FW: Application AB/141/25/PL - Norfolk Centre

Subject: RE: Application AB/141/25/PL - Norfolk Centre

I've just spoken to Martyn, who confirmed that natural larch would be preferred. The materials are specified on the proposed plans, so would you be able to provide me with an amended copy of these? If you could get these to me by Monday that would be much appreciated.

DRAWING
**PROPOSED
PLANS**
DRAWING No
438/03
SCALE 1:100
DATE NOV 2024
REVISION
A
DRAWN LA
CHECKED

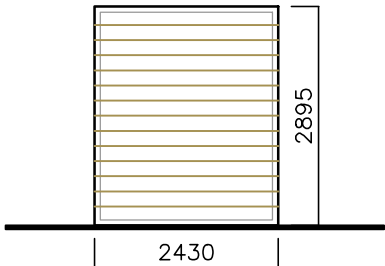
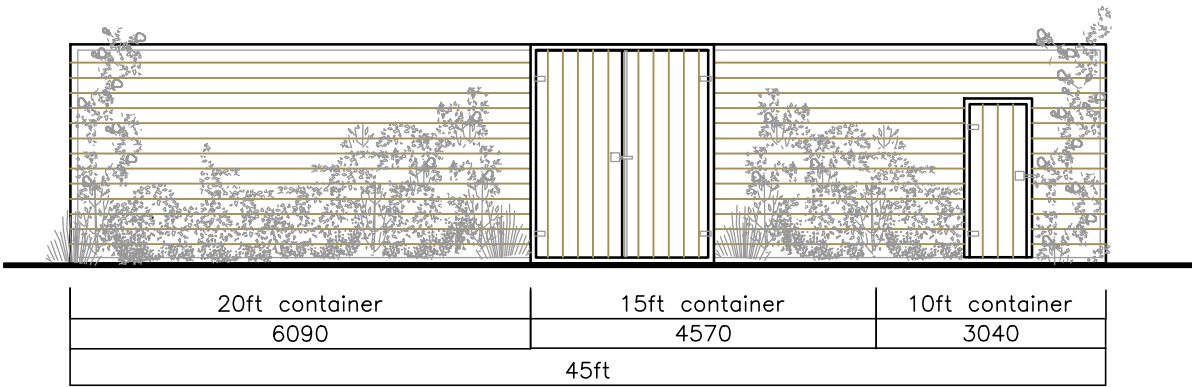
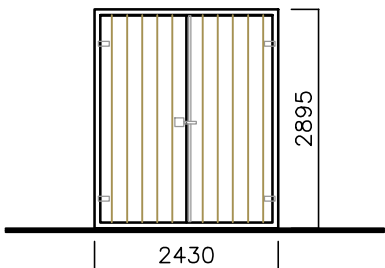
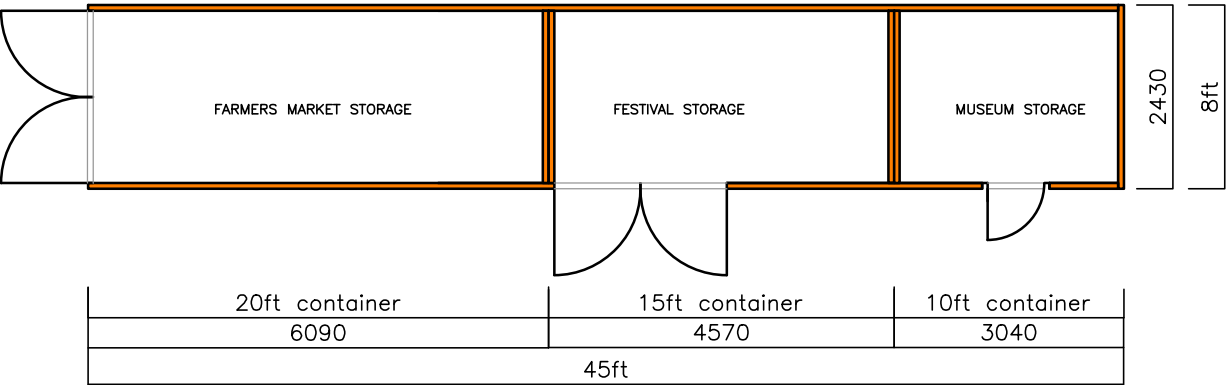
I have now received comments from the conservation officer on your application at the address above, and these comments are attached. As you will see, the comments are generally positive, however, Martyn has raised some concern about the use of stained timber, and stated that unstained timber would be preferred. This echoes the comments made by the Conservation Area Advisory Panel. Please could you take a look at the comments, and consider amending the proposed materials?

Please find attached amended proposed plans stating the use of natural larch.

Please can we propose natural larch, this is maintenance free, durable, natural resistance to rot and pests, ages to a silver grey patina.
